TALLAWONG STATION
PRECINCT SOUTH
SSD 10425

RESPONSE TO SUBMISSIONS

DEICORP PROJECTS (TALLAWONG STATION) PTY LTD

January 2021

Dwg No. DA-110-010, Rev.04

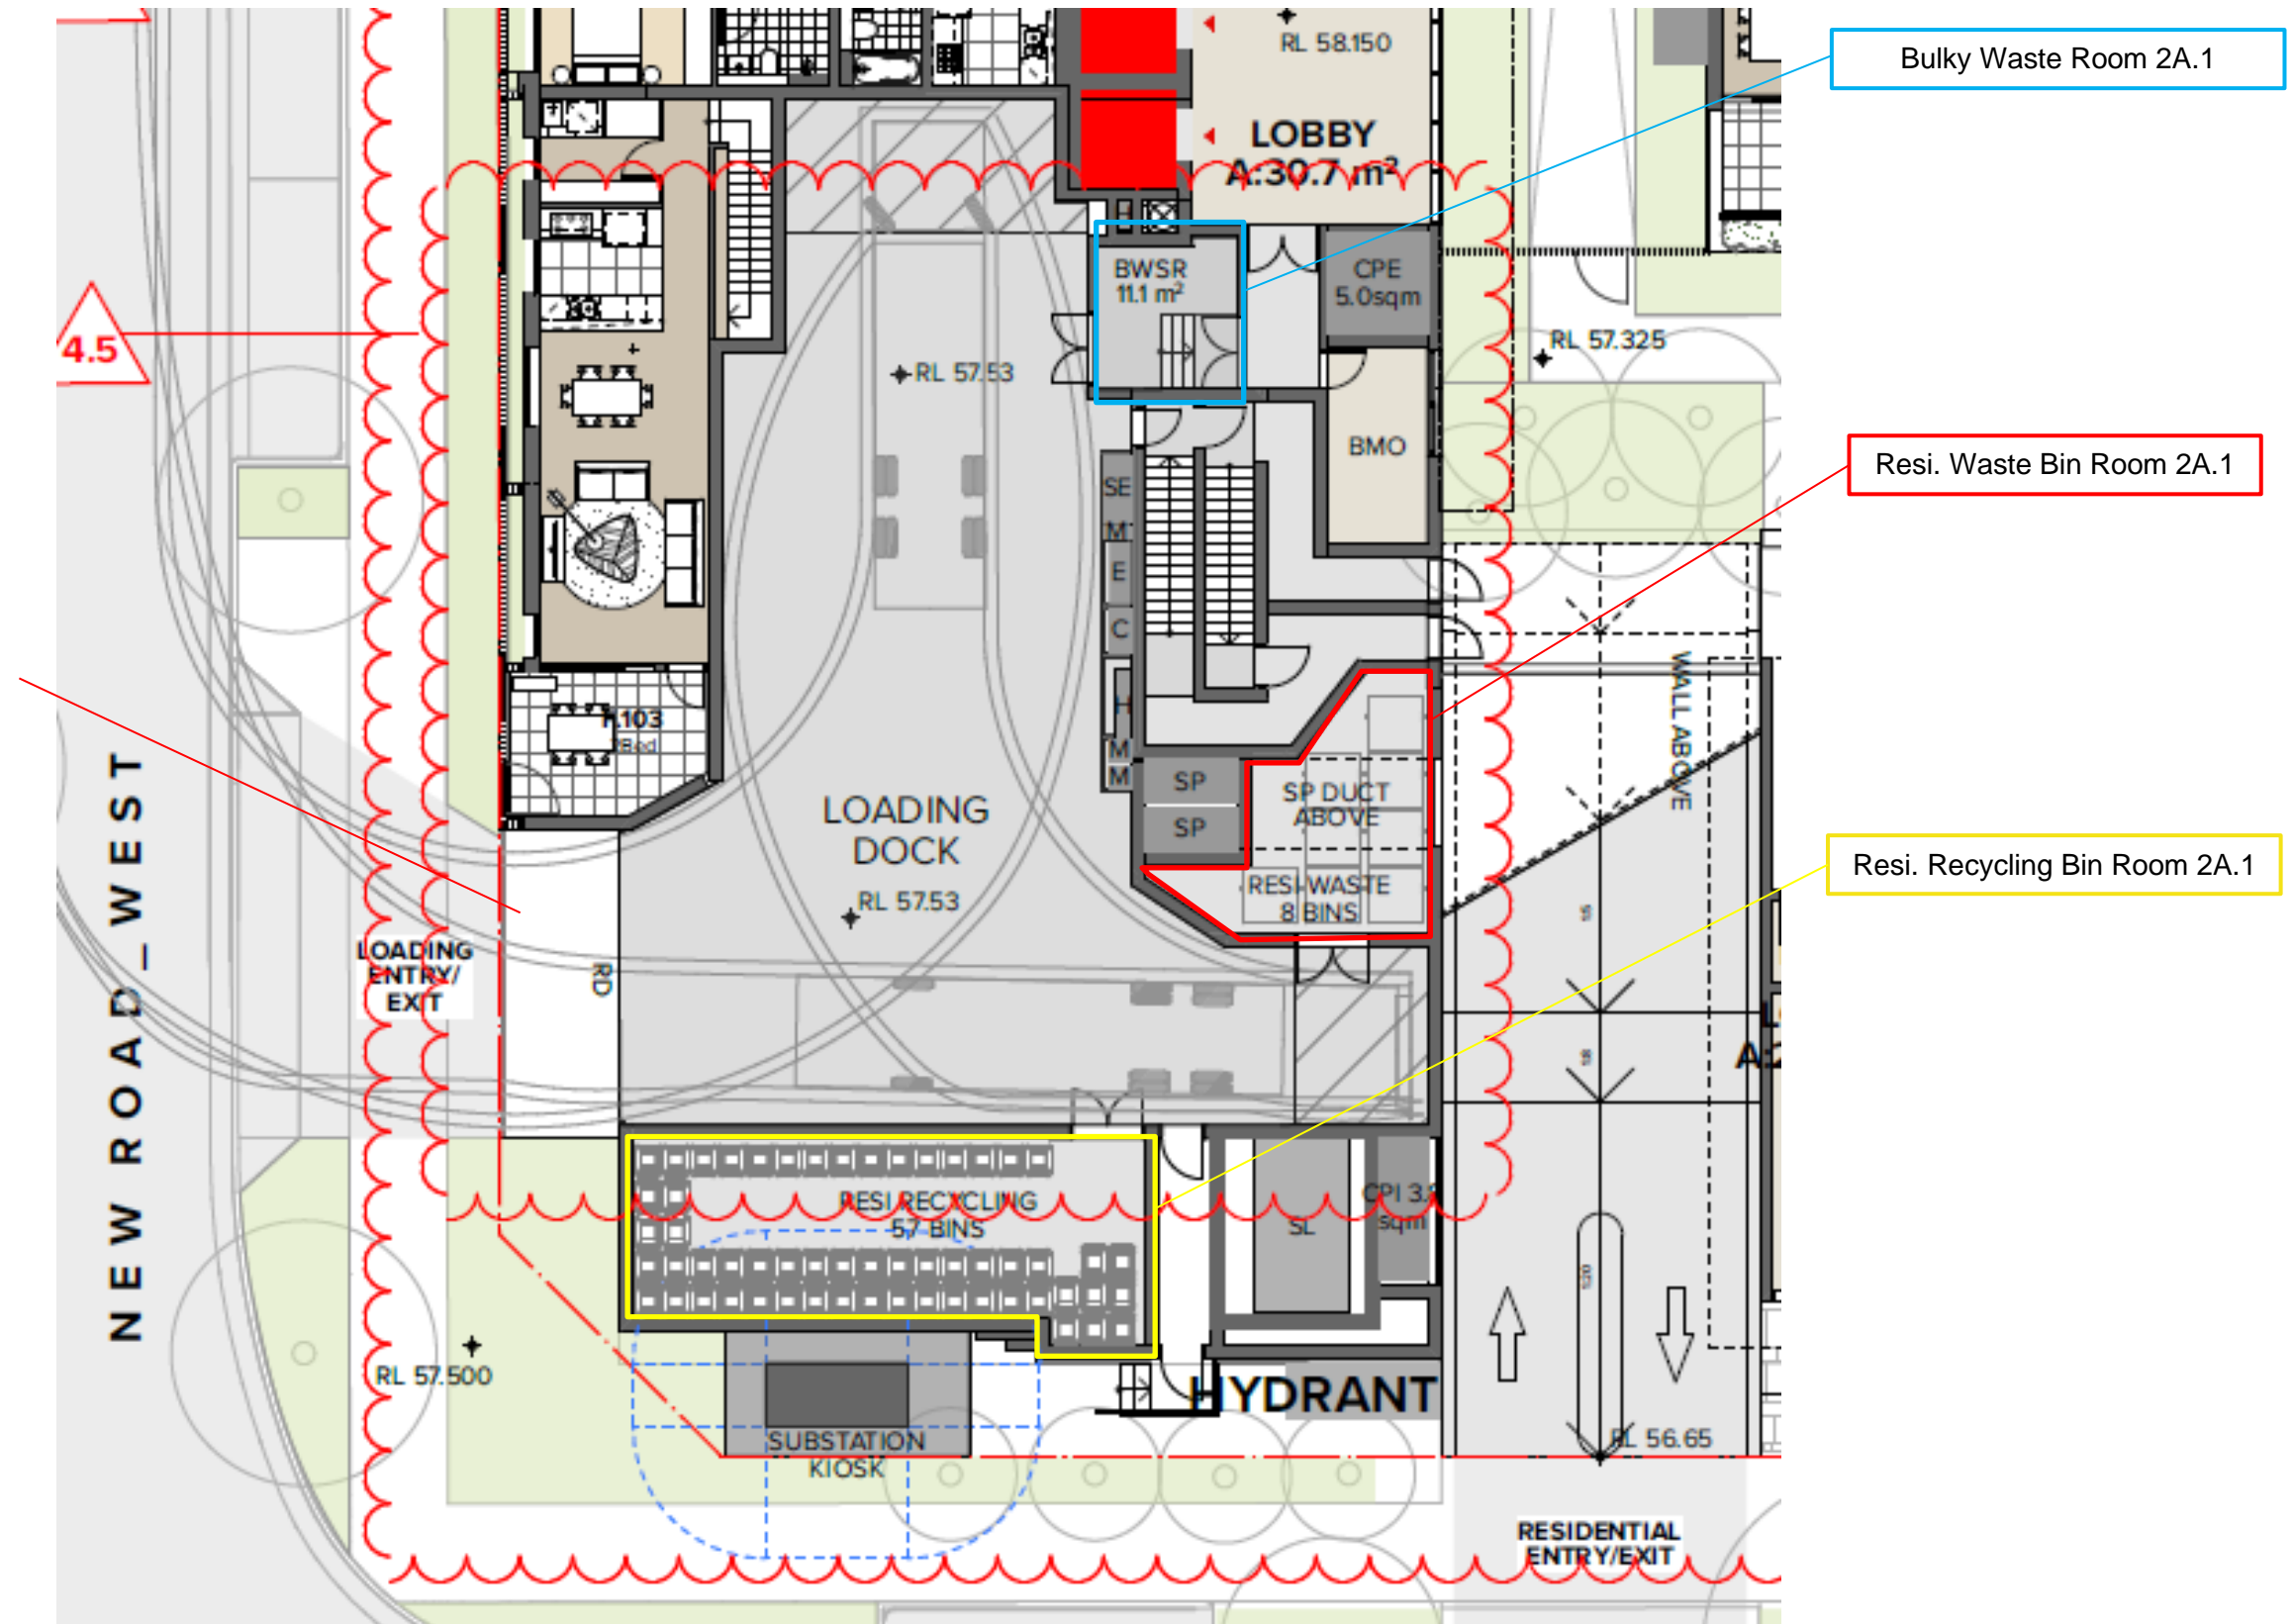
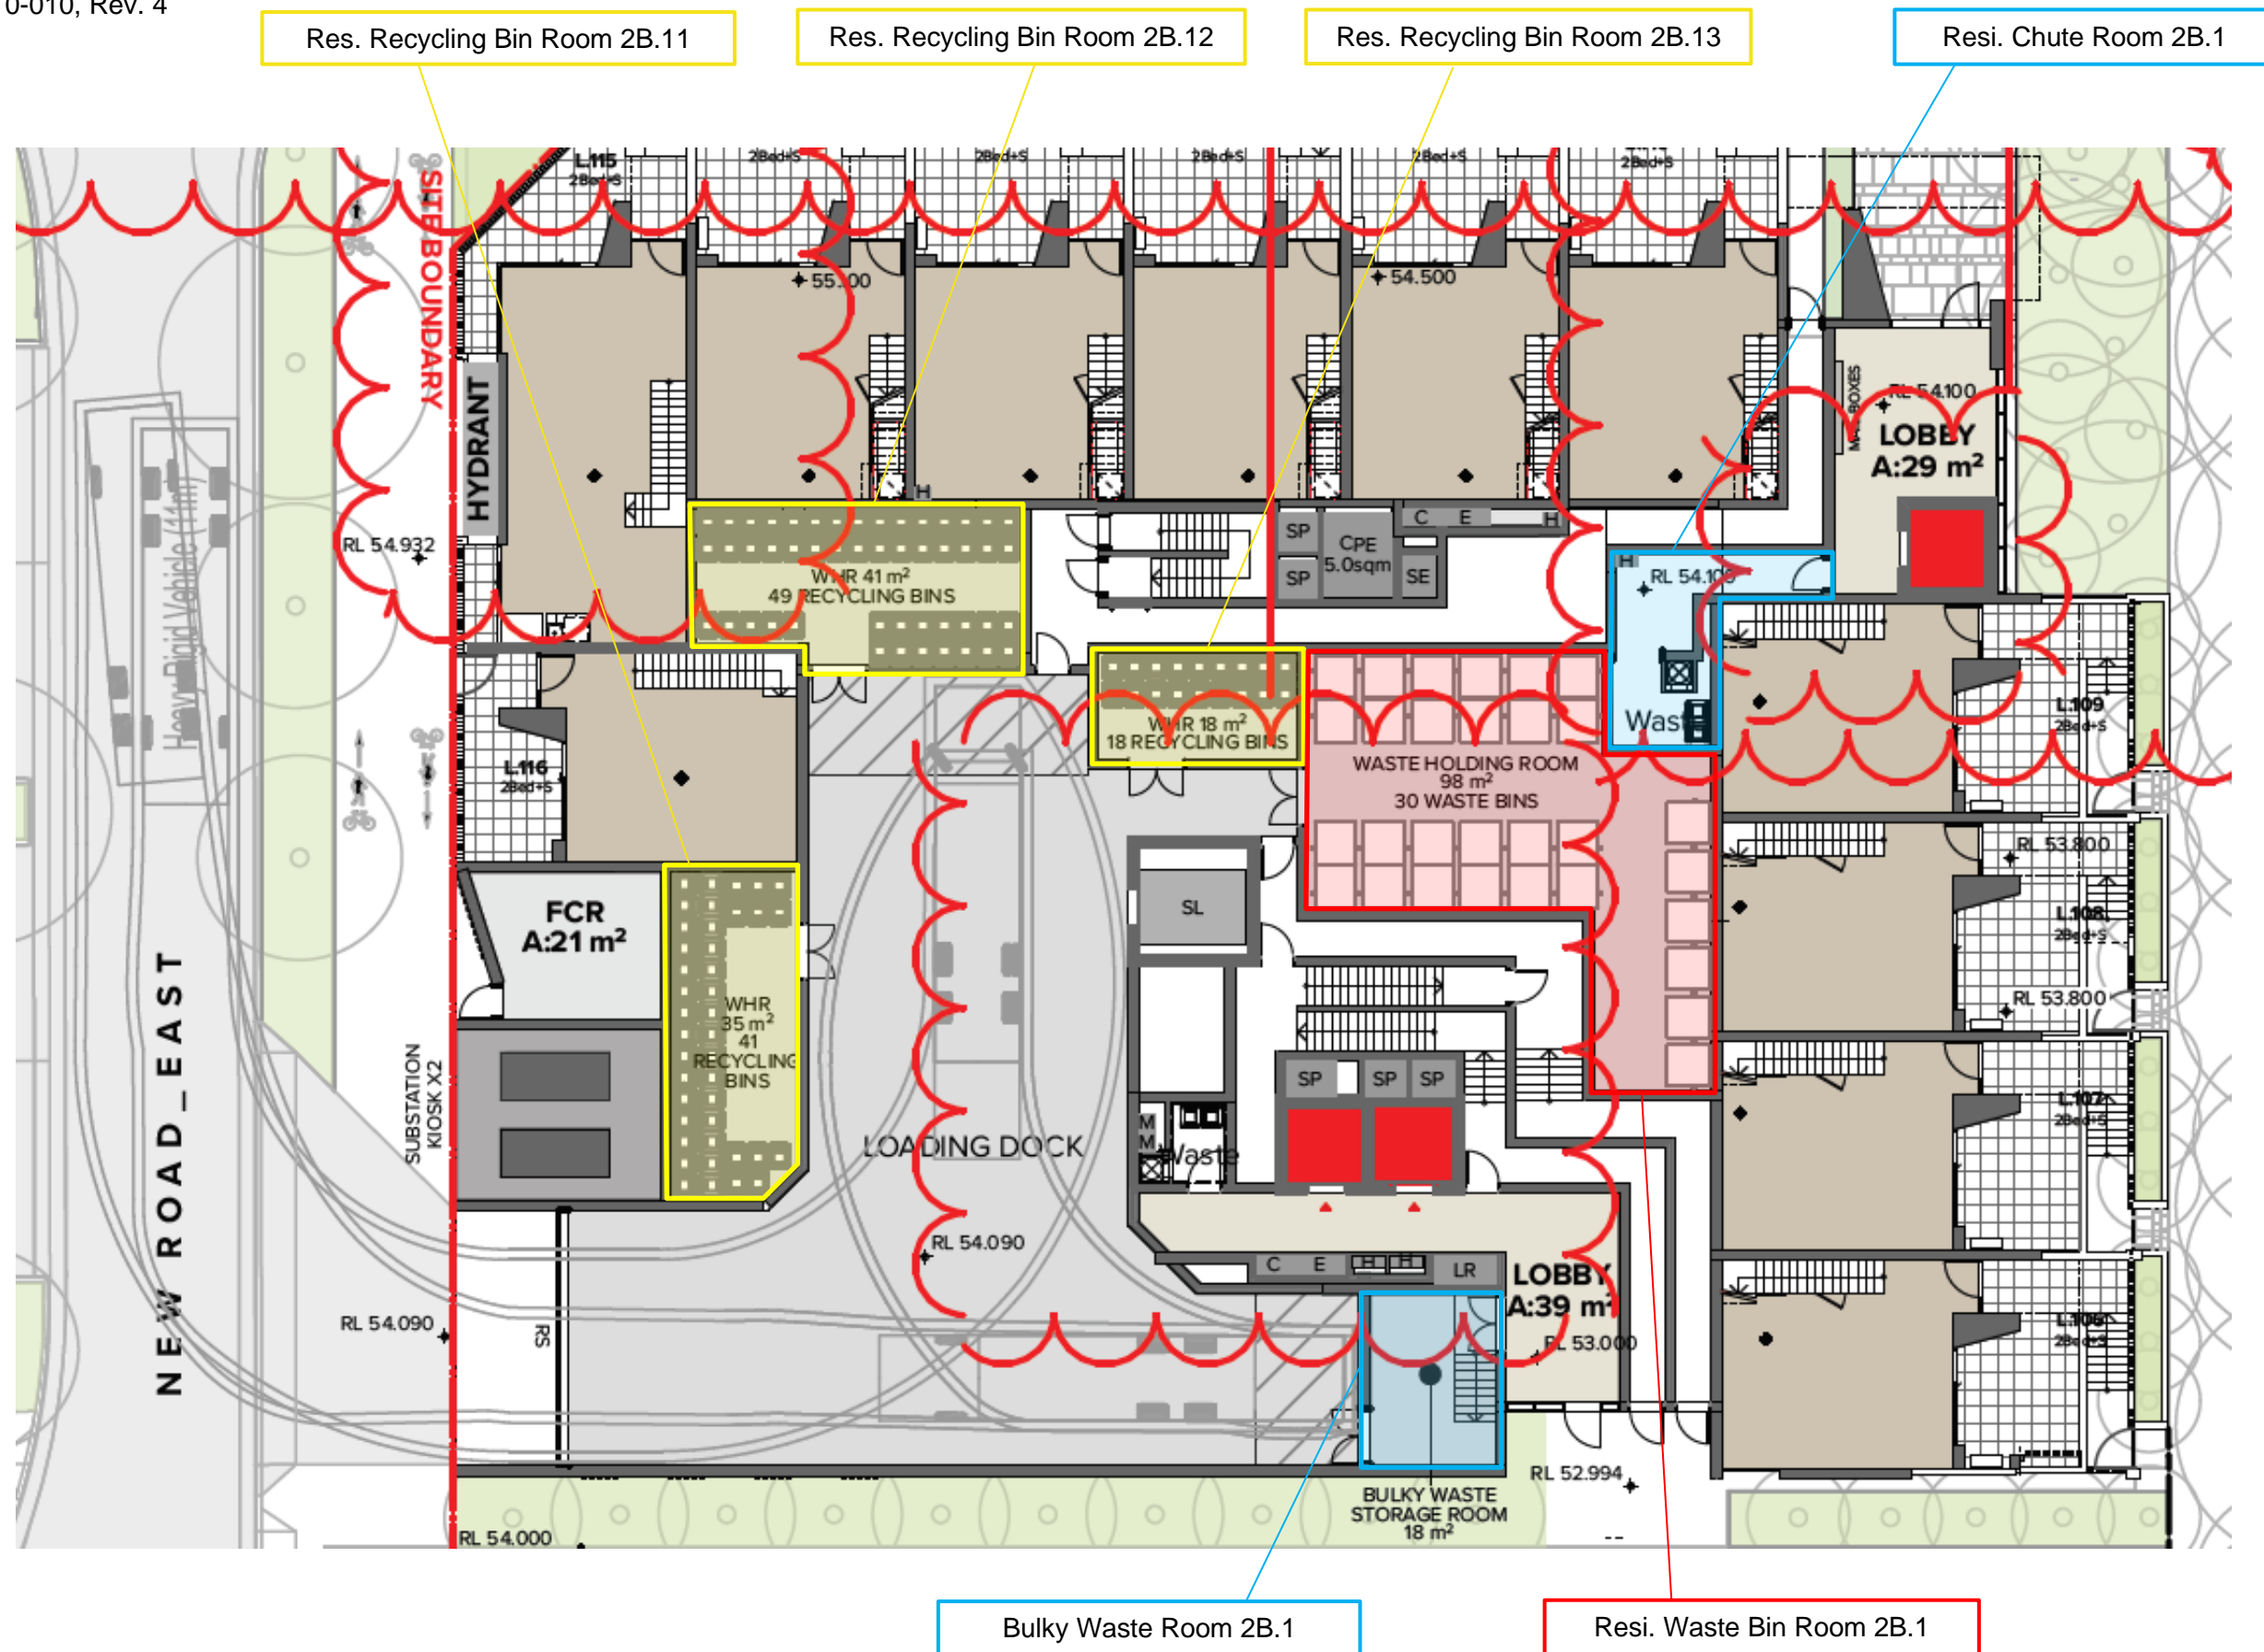
| <p>particularly how solar access and ventilation would be achieved for each of the proposed buildings. This must include (but not limited to):</p> <p>a. solar access diagrams to illustrate how solar access would be achieved for the proposed apartments</p> <p>b. clarify how cross-ventilation and natural ventilation are achieved for apartments affected by rail and road noise.</p> | <p>submitted with the Development Application included solar access diagrams which identifies every apartment of the 987 apartments which achieves compliant solar access. This submission is also accompanied by sun-view diagrams as well as a schedule of apartments which also identify which apartments achieve a compliant level of solar access.</p> <p>In relation to ventilation for apartments affected by noise, it is noted that the Department has recently confirmed in the assessment report for SSD application 7749 at 11 Gibbons Street, Redfern that “the ability to provide natural cross ventilation and acoustic privacy is not mutually exclusive, as both are not required at all times. In noisy periods, windows and doors can be closed to obtain acoustic privacy and appropriate airflow can be supplemented...”. An updated acoustic report prepared by Koikas Acoustics accompanies this submission which provides additional detail in relation to how ventilation is proposed to be supplemented for apartments affected by rail and road noise. In summary, a duct containing a fan will be installed into the external façade of noise affected apartments to supply outside air to the habitable spaces of the apartment.</p> <p>Turner Architect</p> <p>The following attached documents demonstrate the proposal’s compliance with the ADG:</p> <p>‘Solar and Cross-Ventilation Diagrams’ (DA-720-010 – DA-720-110).</p> <p>‘Views from Sun’ (DA-715-001 – DA-715-007)</p> <p>‘18095_Development Schedule’ listing solar access and cross ventilation compliance.</p> <p>To address noise issues for apartments facing Schofields Road, windows have been added to the niche in buildings Q, R and S. These windows provide alternative ventilation if the window facing Schofields Road is closed.</p> | <p>Appendix 7</p> <p>Appendix 9</p> |

| | <p>Please refer to the following architectural drawings: DA-110-010 – DA110-090 DA-113-009 – DA-113-080</p> | <p>Appendix 1</p> |
